**HINCKLEY NATIONAL
RAIL FREIGHT INTERCHANGE**

Project reference TR050007

**Geometric Design Strategy Record (GDSR) – M69 Slip
Roads and Comment Log**

Hinckley National Rail Freight Interchange (NRFI) Development Consent Order (DCO) - M69 J2 Scheme Geometric Design Strategy Record (GDSR) Review

J2 NORTHBOUND DIVERGE LONGSECTION  
SCALE: H 1:2500, V 1:500. DATUM: 95.000

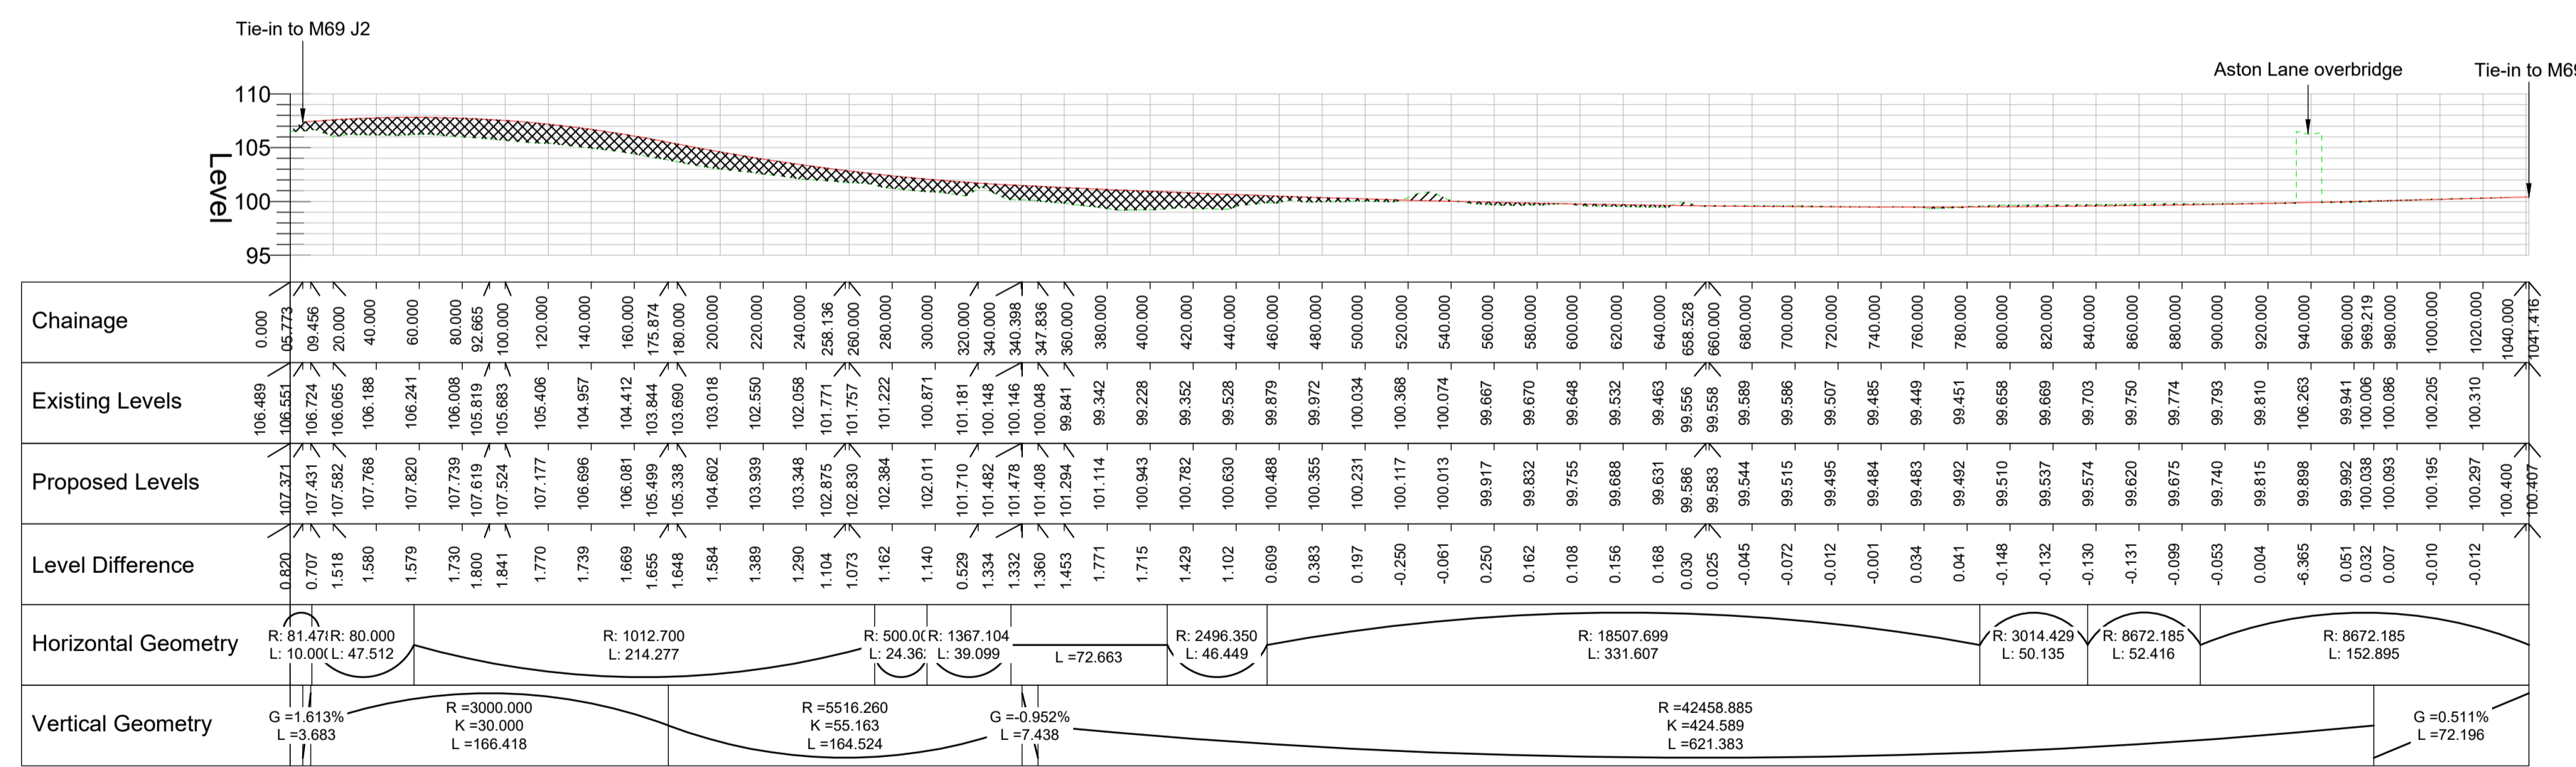
9	Vertical Design	We are unclear why 6% max gradient has been referenced in relation to the requirement for the new southbound merge slip road?	This is based on CD122 paragraph 5.7 and a section has been added to the report to reference this.	Noted and accepted*.	
10	Vertical Design	It should also be noted that gradients of less than 0.5% on a kerbed road will require false channel paths for drainage (see CD 109 cl. 5.2). This is an issue that should be raised and discussed with the Drainage Asset Lead as appropriate.	This is noted.	No further comment.	
11	Cross Sections	Reference to how cross sections have been determined	Paragraph added to revised report.	Noted and accepted*.	
12	Cross Sections	Traffic flows require a DG2A cross section on the diverge whereas a DG2C cross section is provided.	This has been amended with the hard shoulder tapered out over the length of the nose. This does not affect the main line, nor the location of the departures from standard.	The GDSR still refers to a DG2C diverge cross section, which is not consistent with the diverge flow calculation provided in Appendix B. Clarification is required to allow continuation of cross sections review.	This is amended in the P03 version to read DG2A
